DECISION DELEGATED TO HEAD OF PLANNING

Application No: H09-0164-26 **Applicant:** Kings Civils
Proposal: Proposed Detached Garage
Location: Land South Of Tudor Lodge Fen Road Holbeach
Terminal Date: 16th April 2026

PROPOSED SITE PLAN (Dwg TL-SH-GH-AR-001 P02)

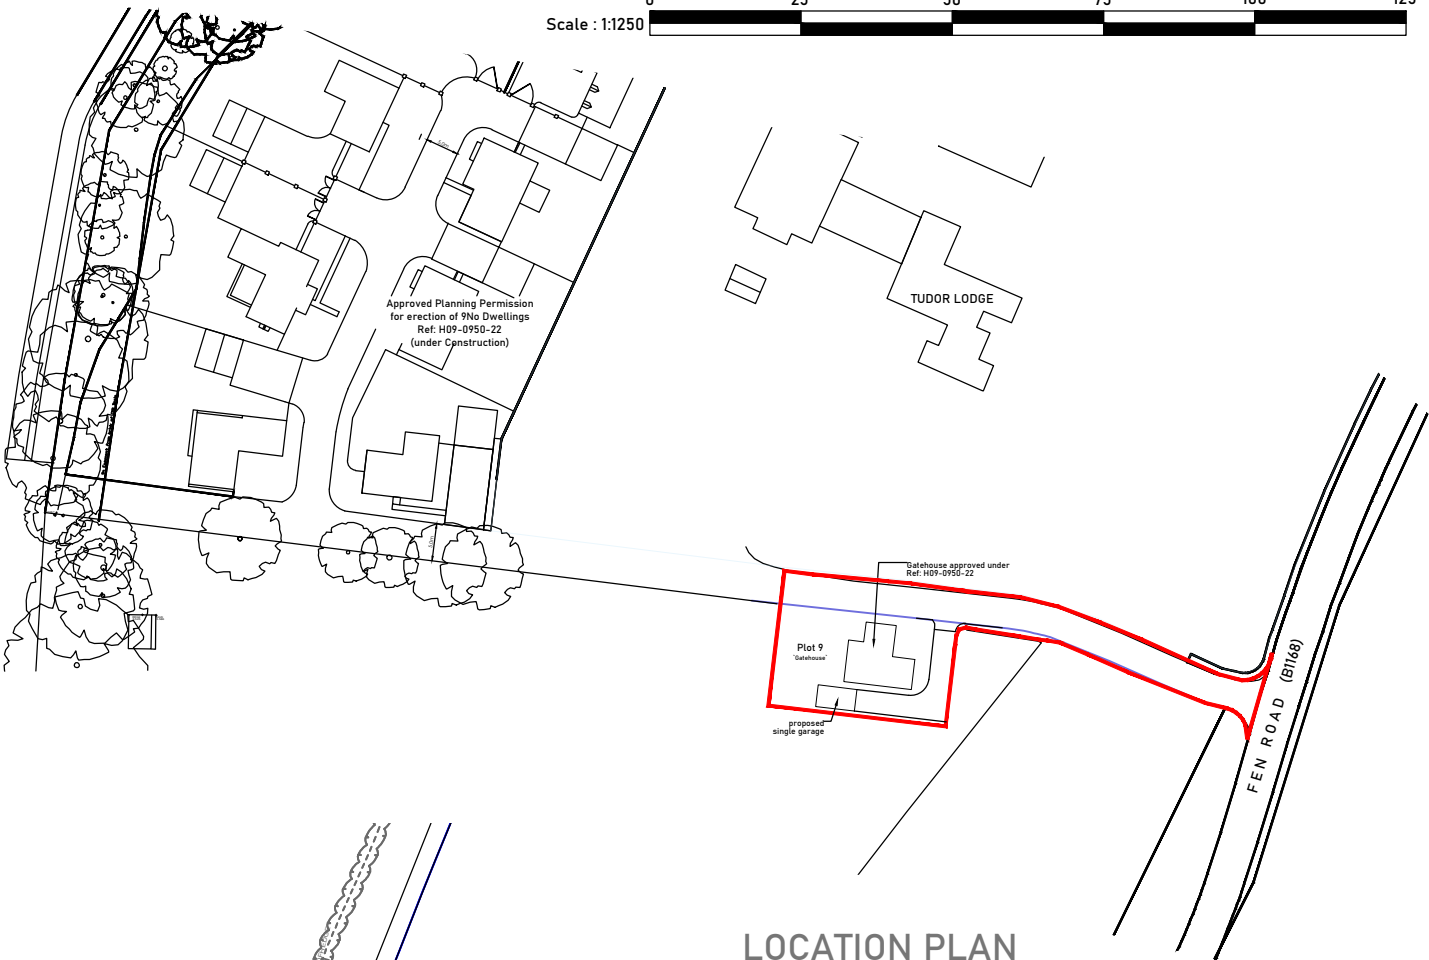
The site layout shows that the building is proposed to the south-west of a dwelling; however, there is not a dwelling within the site. Approval was granted for a dwelling (Plot 9) within the site under planning permission H09-0950-22; however, permission H09-0950-22 has been made invalid as the developer commenced development before pre-commencement conditions were discharged and as such, it is not considered that a lawful commencement has been made. An application is yet to be submitted to re-apply for planning permission.

The proposed development seeks to extend the garden area and driveway of Plot 9 to the south of the previously approved curtilage of the site under permission H09-0950-22. Therefore, the proposal also requires permission for a change of use. Although this is not referred to in the description of development, the change of use of the land has also been considered as this is clearly shown within the submitted site plan.

Therefore, although the submitted site plan indicates that a dwelling has permission to be constructed within the site under permission H09-0590-22, this is incorrect as this permission is no longer valid. As such, the proposal seeks permission for a residential garage in the countryside.

of the dwelling was proposed to be larger than under the original permission H09-0590-22. Under the current proposals, the curtilage is smaller than that previously refused; however, the curtilage would still extend further to the south than previously permitted by permission H09-0590-22.

The submitted Flood Risk Assessment (FRA) contains a section regarding how the sequential test has been applied to the development. The FRA sets out "As such, opportunities to undertake the development at an alternative site with a lower flood risk are limited". No evidence of a site search exercise has been provided, nor any evidence of whether sites have been considered or discounted. As such, it is considered that insufficient information has been provided to demonstrate if the sequential test has been passed.
